TO: All Staff
FROM: Public Works Planning Review Team
DATE: January 31, 2020
SUBJECT: Indian Camp Campground CU-19-00006

The Department of Public Works has reviewed the permit for the WFDW Durr Road Conditional Use Permit and has the following comments:

INDIAN CAMP EXPANSION
SITE LAYOUT PLAN

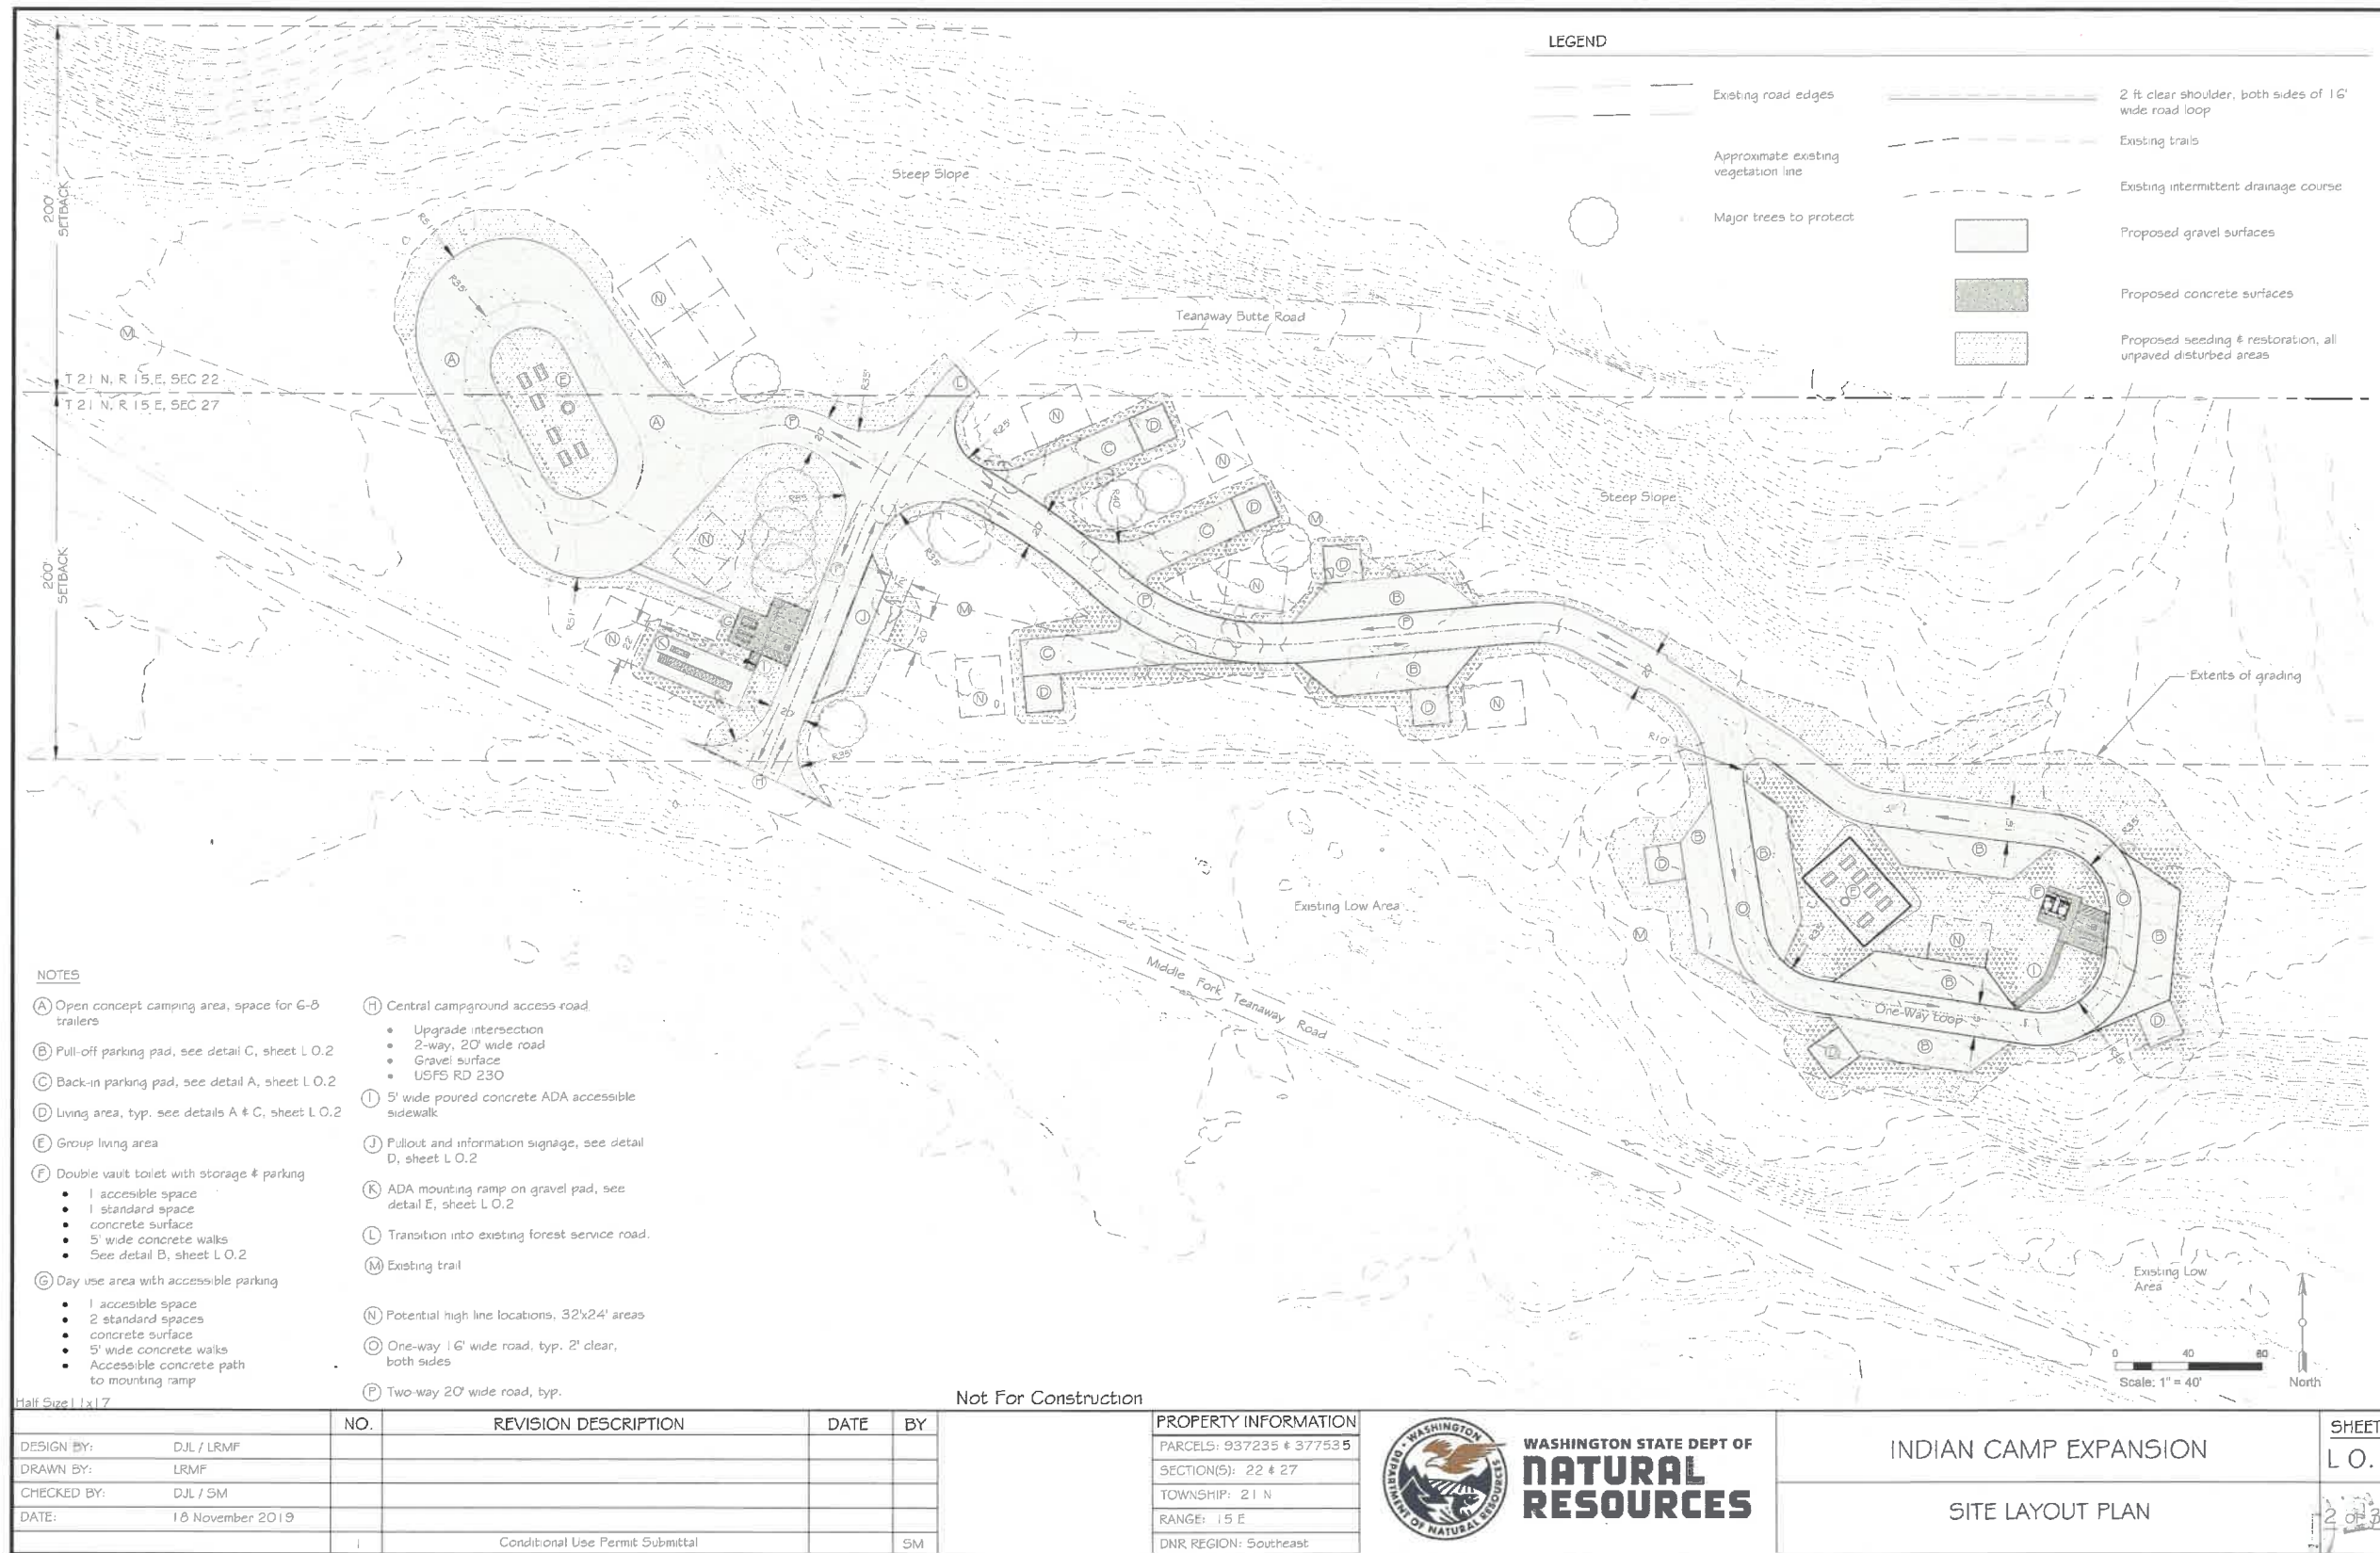
- A. The Indian Camp Campground will use the existing accesses to Teanaway Road.
- B. The expansion is exempt from road and grading permits. **Kittitas County Road Standards 14.05.060 Exemptions** excludes construction activities performed by a state or federal agency with oversight of a licensed civil or geotechnical engineer.
- C. The road network is required to meet International Fire Code Standards. Portions of the proposed roadways do not meet IFC minimum width requirements. Additional coordination with the Kittitas County Fire Marshall may be required.
